**RE: Sotogrande Housing  
Conceptual Grading and Drainage Plan  
Stamp Date: 10/3/17  
Hydrology File: M15D023H**

Based upon the information provided in your submittal received 10/3/2017, the Conceptual Grading and Drainage Plan **is not** approved for Preliminary Plat and Site Plan for Building Permit. The following comments need to be addressed for approval of the above referenced project:

CONCEPTUAL GRADING PLAN - NORTH HALF
SCALE: 1" = 30'

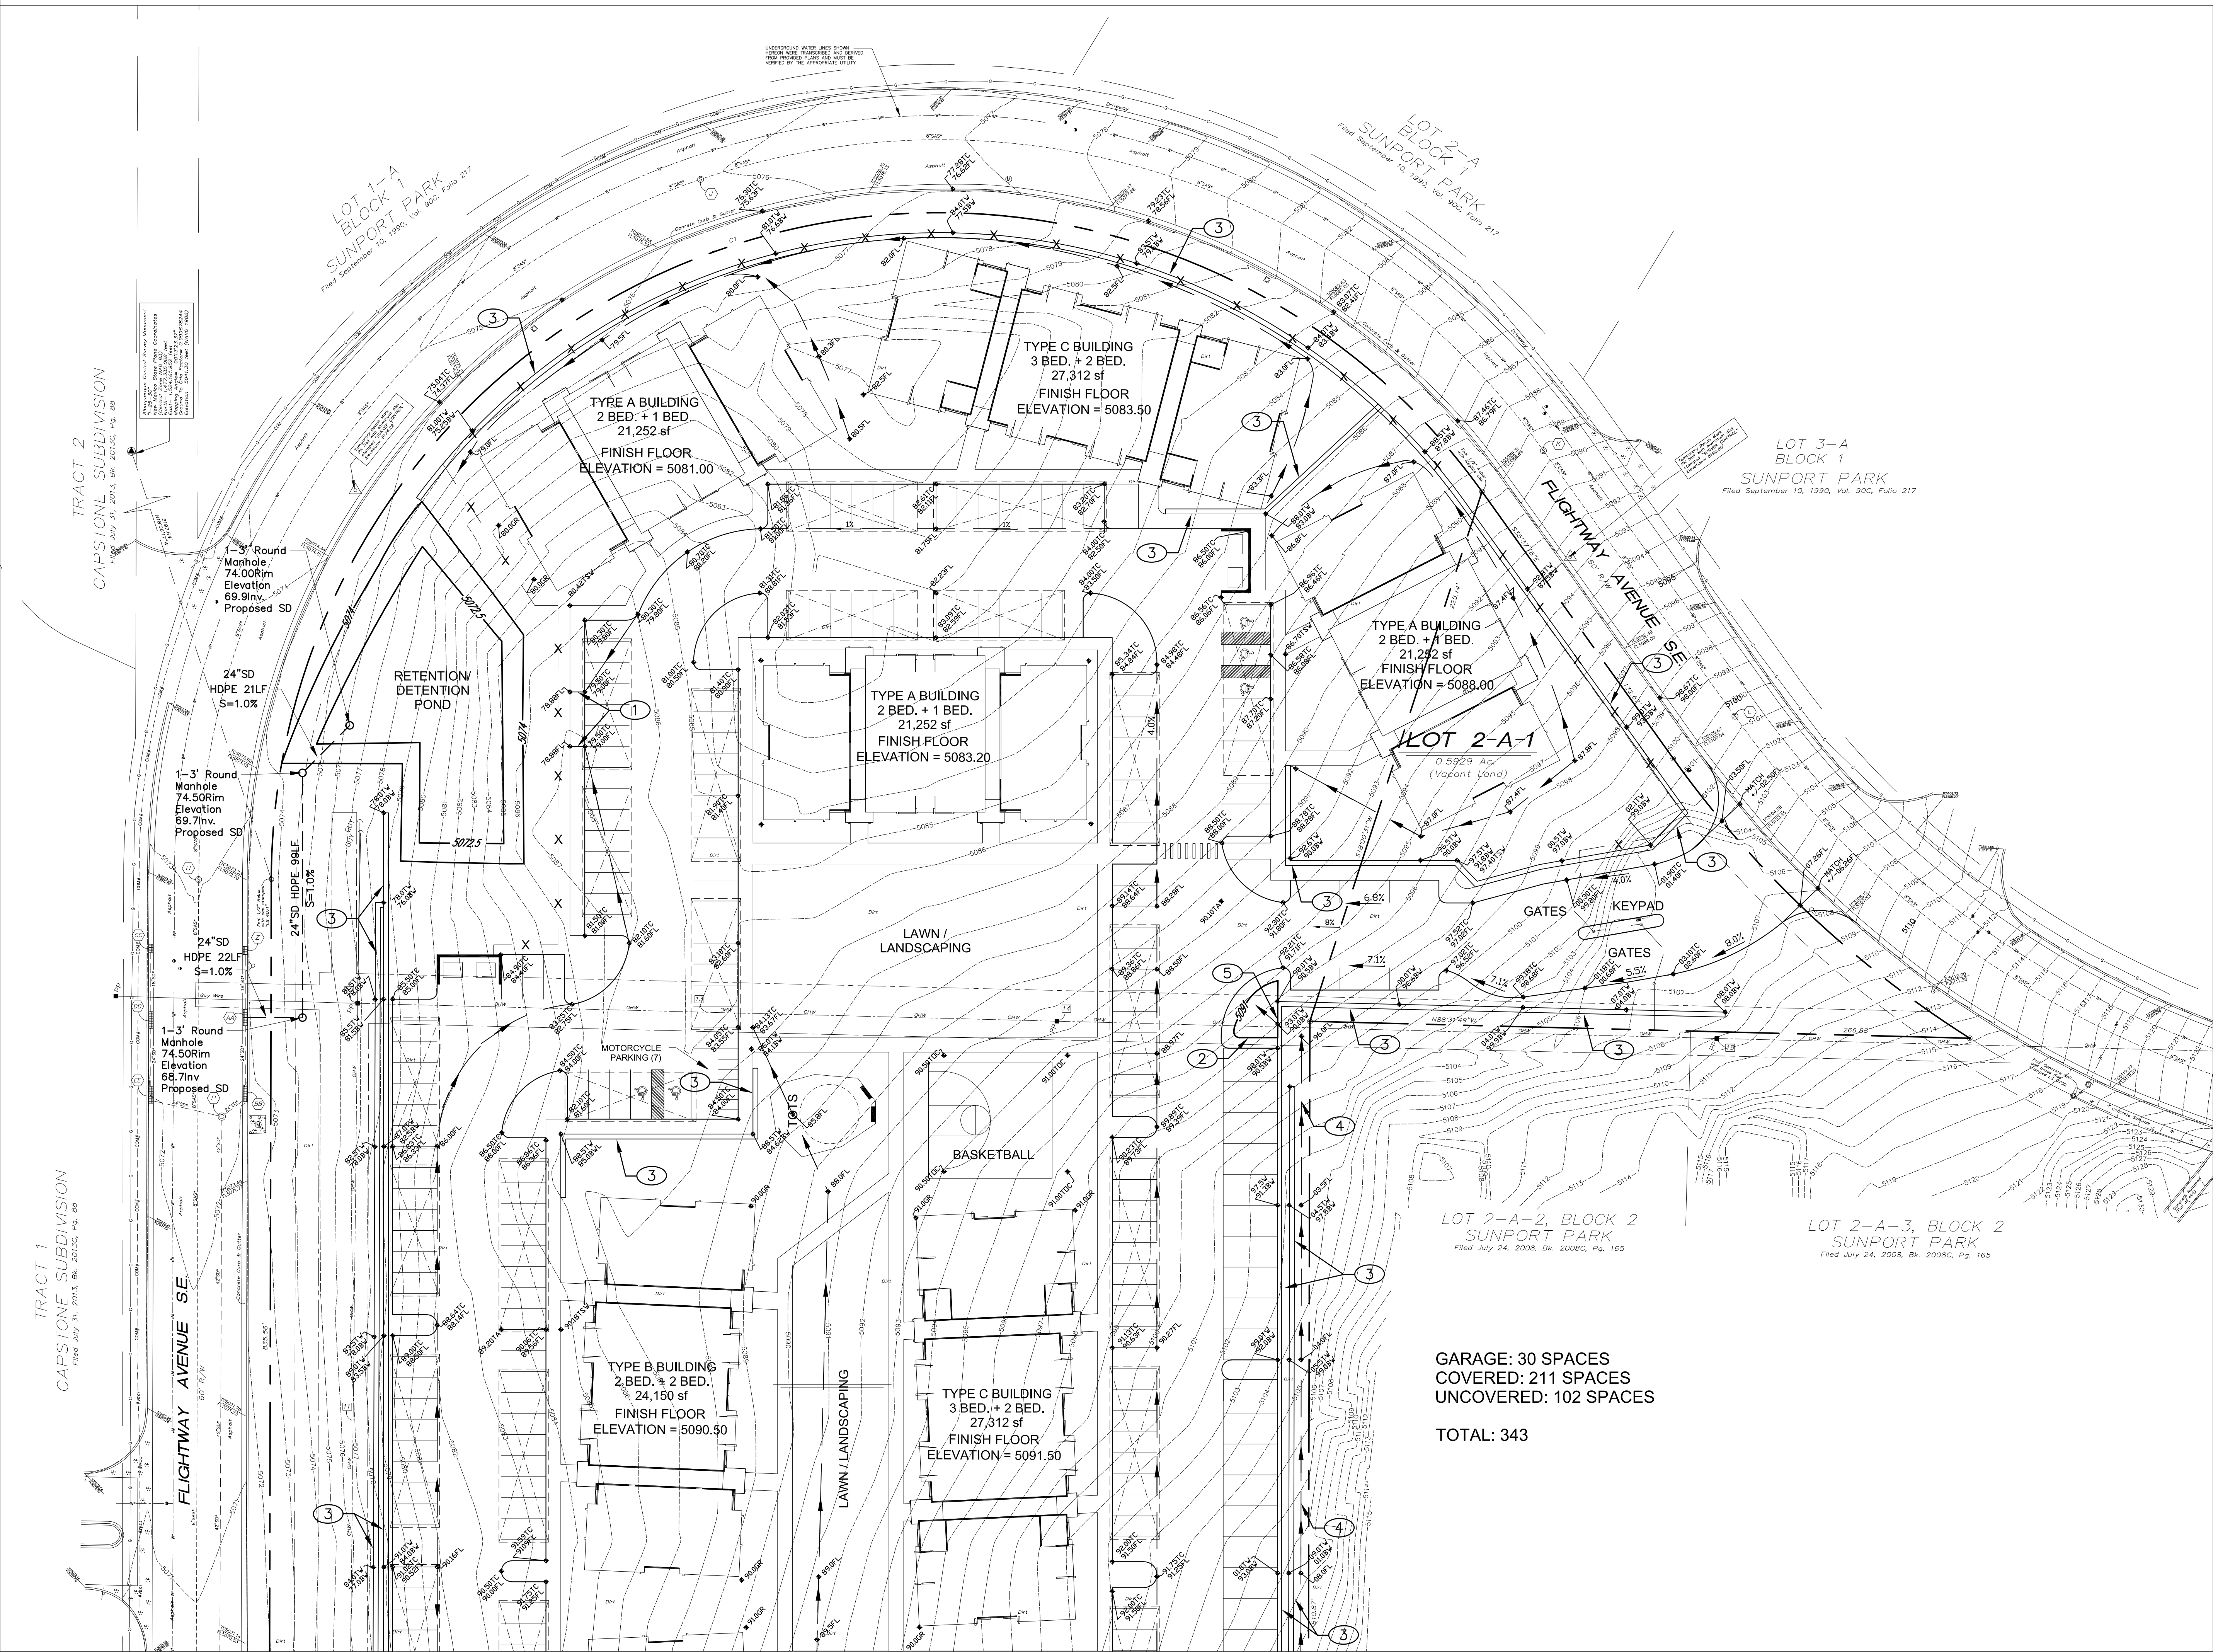
3. Sheet CIVD2 & CIVD3. Please add proposed contour lines throughout the project. Since there are multiple building, the proposed contours will help spot drainage issues. I'm particularly concerned with how you are tying back into the existing contours along Woodward Road and Flightway Avenue.

4. Sheet CIVD2 & CIVD3. Please label both ponds as Detention Pond w/ First Flush rather than Retention Pond.
5. Sheet CIVD2 & CIVD3. Please provide pipe calculations showing that both outfall pipes can handle the required release rates for each pond.

6. Sheet CIVD2 & CIVD3. Please fix the leaders on the Construction Note callouts. Some of the arrows are not pointing to the right object.
7. Sheet CIVD3. I believe you have a design changed that was not corrected. You call out a 22 feet curb cut for drainage access into the proposed detention pond. However this is just a sidewalk right behind a proposed Garage. You also are showing what appears to be a concrete channel at the south side of the detention pond that extends into two parking spaces but this is not called out. Please clarify which one is the drainage structure for the detention pond.
